Jeanette Mose Subdivision

A portion of the Southeast Quarter of Section 8, Township 12 South, Range 64 West of the 6th P.M., County of El Paso, State of Colorado.

Job No. 201005 JEANETTE MOSE SUB. DATE March 15, 2021

Job No. 201005 JEANETTE MOSE SUB. DATE March 15, 2021

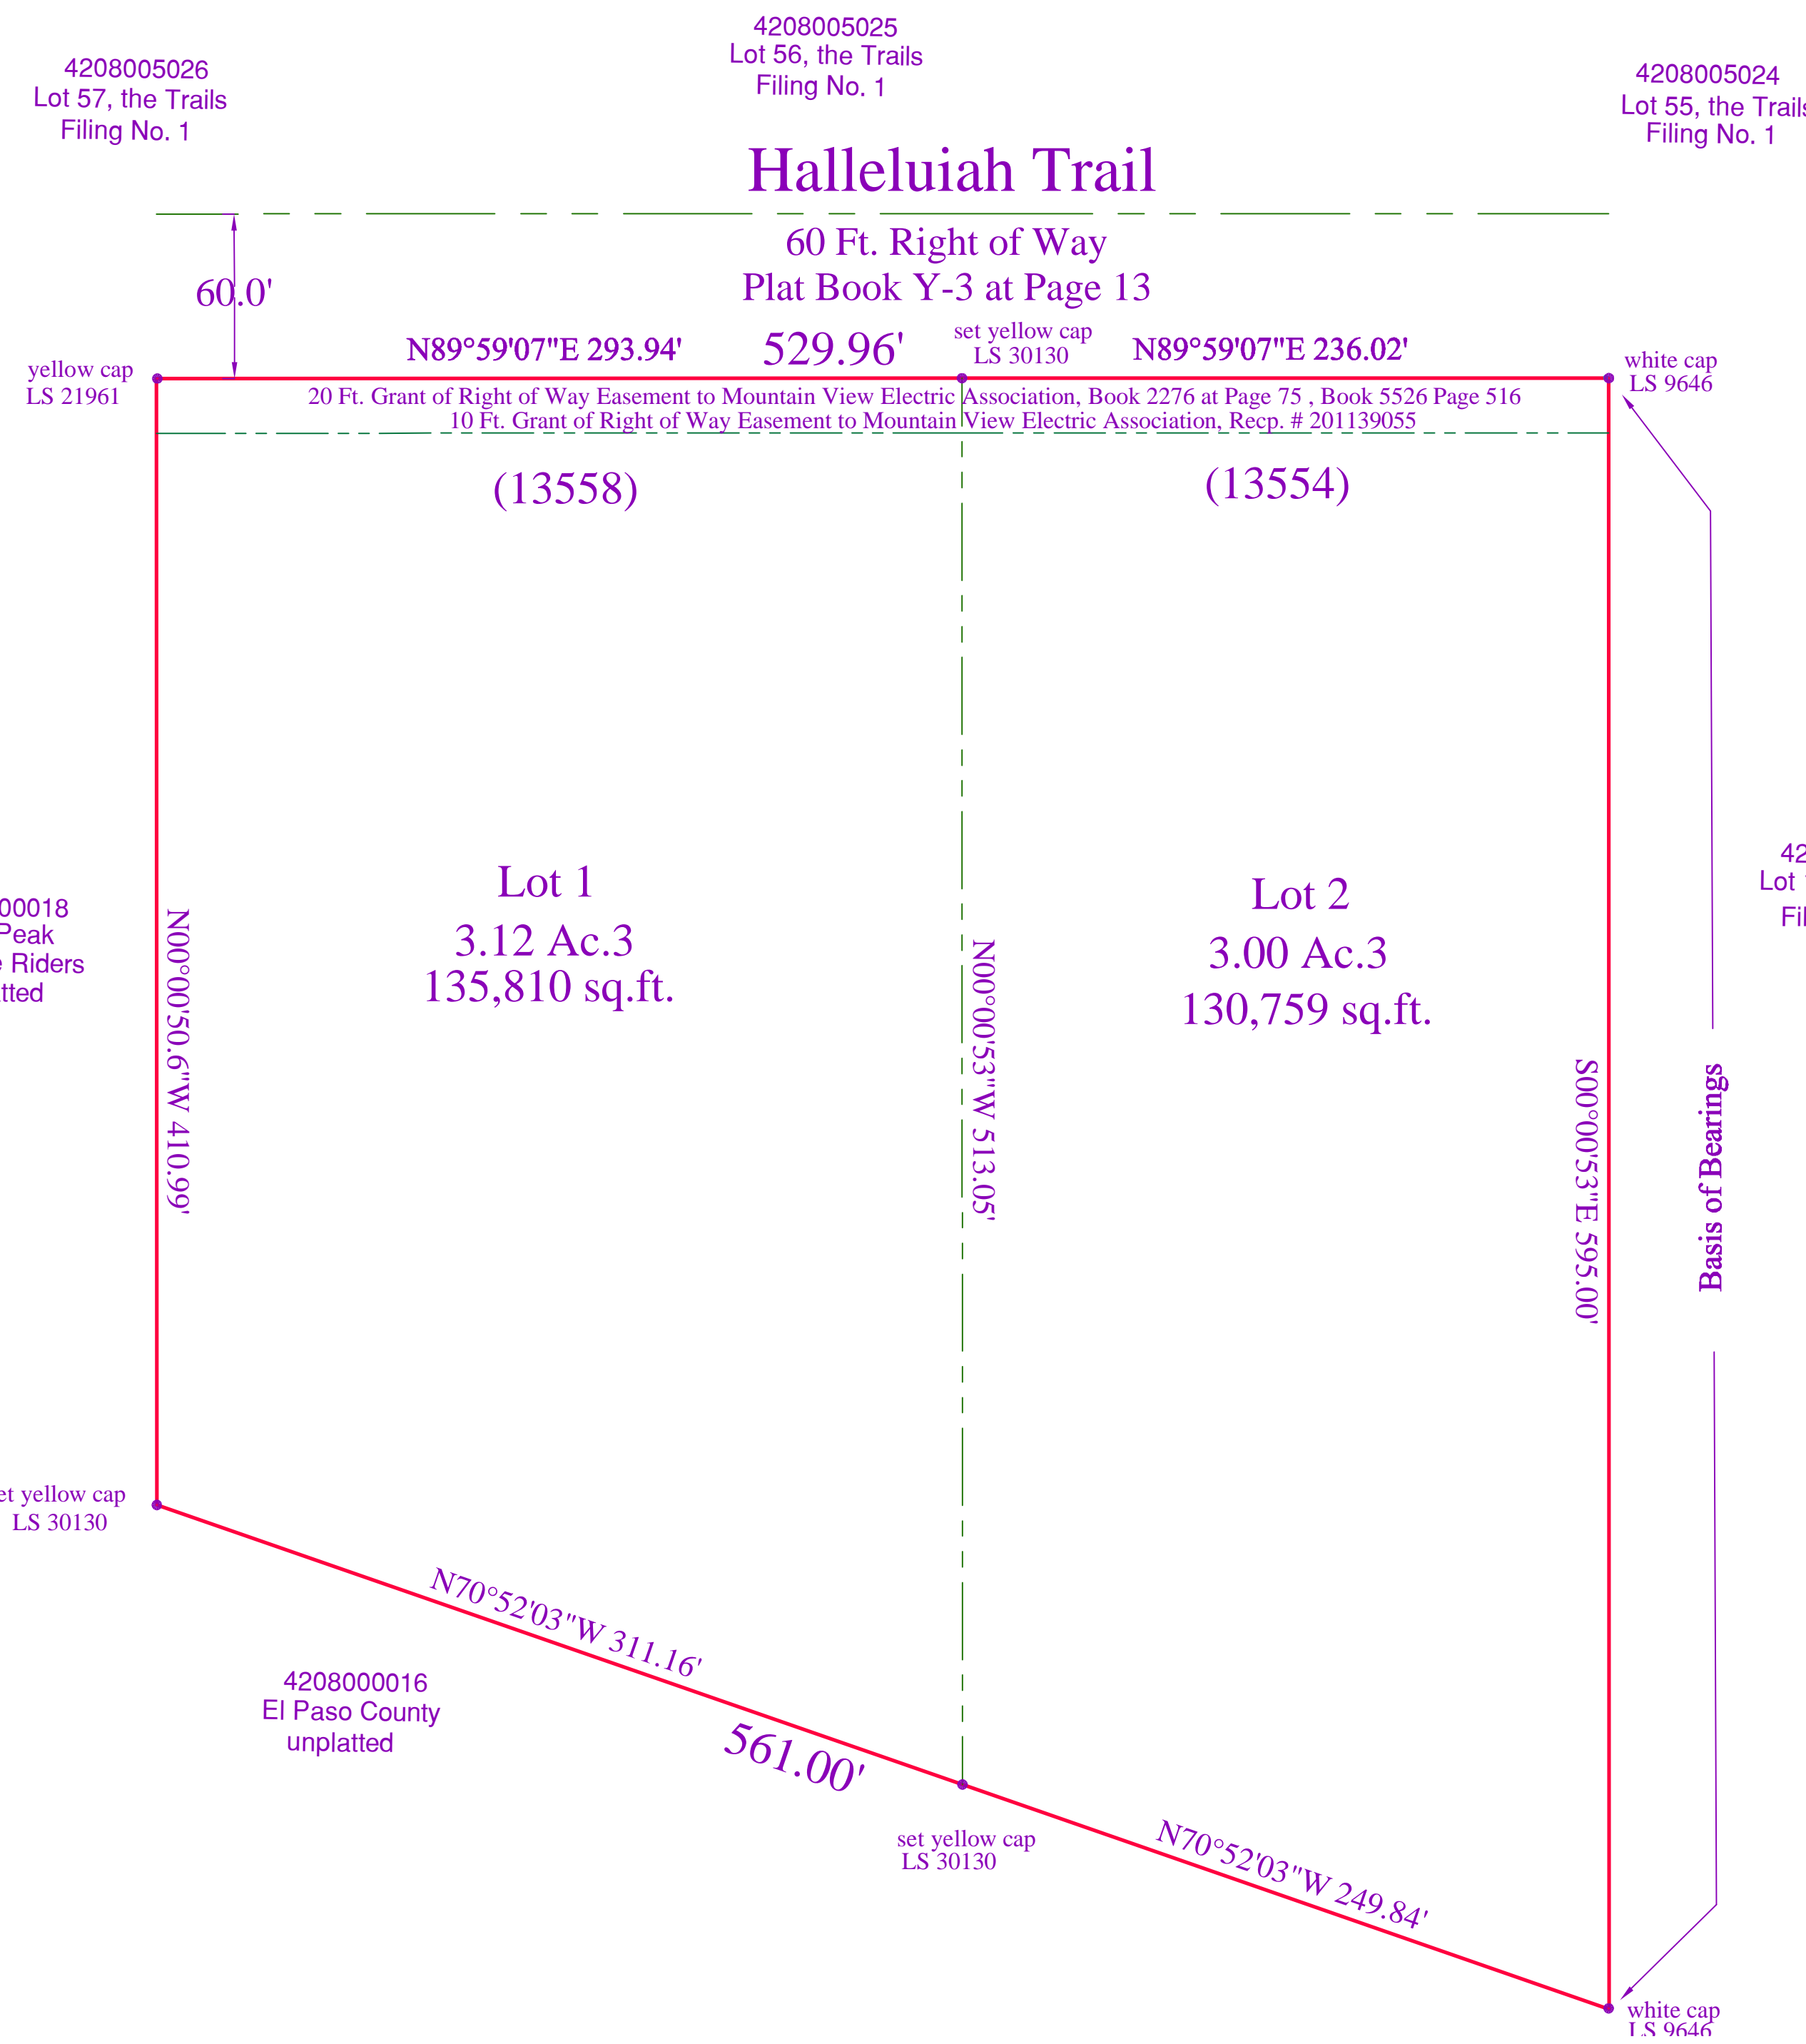
Hazard areas, per CGS comments, are still not shown as no-build areas on the plat. Please revise

Add note regarding underdrain requirements

OWTS Report must be updated to include findings for lot 2, thus altering language in this note.

Please add this signature block
